From: Wilson, Susan <susan.wilson@naturalengland.org.uk>
Sent: 21 December 2020 15:40
To: Richard Cram <rcram@ableuk.com>; Gooch, Hannah <hannah.gooch@naturalengland.org.uk>
Cc: Tailor Kishor <k.tailor@humberlep.org>; Forecast, Lauren <Lauren.Forecast@naturalengland.org.uk>; Neil Etherington <netherington@ableuk.com>
Subject: RE: AMEP Non material Change Application

From: Richard Cram <rcram@ableuk.com>
Sent: 18 December 2020 14:39
To: Wilson, Susan <Susan.Wilson@naturalengland.org.uk>; Gooch, Hannah <Hannah.Gooch@naturalengland.org.uk>
Cc: Tailor Kishor <k.tailor@humberlep.org>; Forecast, Lauren <Lauren.Forecast@naturalengland.org.uk>; Neil Etherington <netherington@ableuk.com>
Subject: AMEP Non material Change Application

Figure 5. Location of Area A within AMEP DCO in relation to the constructed mitigation site at HMWG.

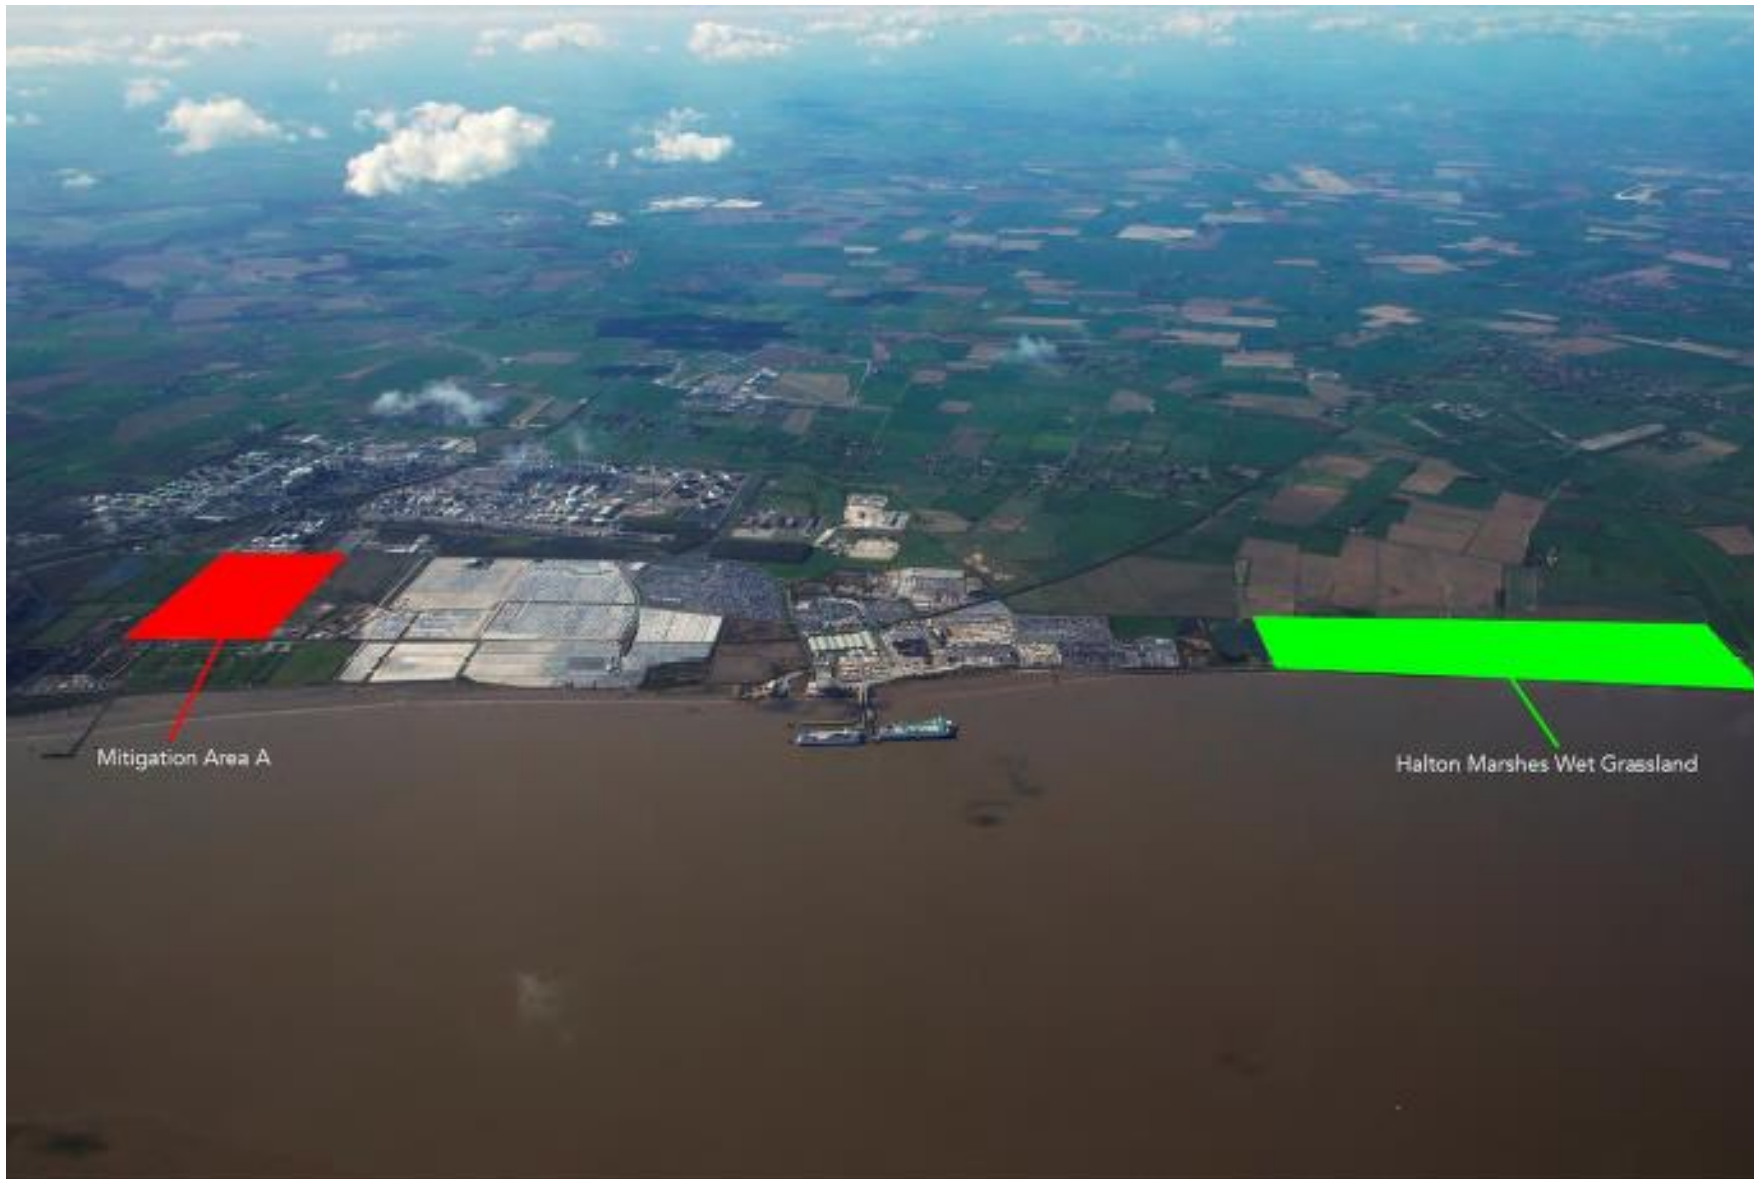
4. *'It is unclear why the red line boundary remains in the same location, although it understood that this would now be removed from the DCO development limits.'*

The boundary delineates the Order land and is unchanged. Please refer to the draft amendment Order which redefines the Order Limits to preclude development on the site of the 'former Mitigation Area A' under the DCO. Can you confirm this clarifies the matter.

NE comment: point is clarified.
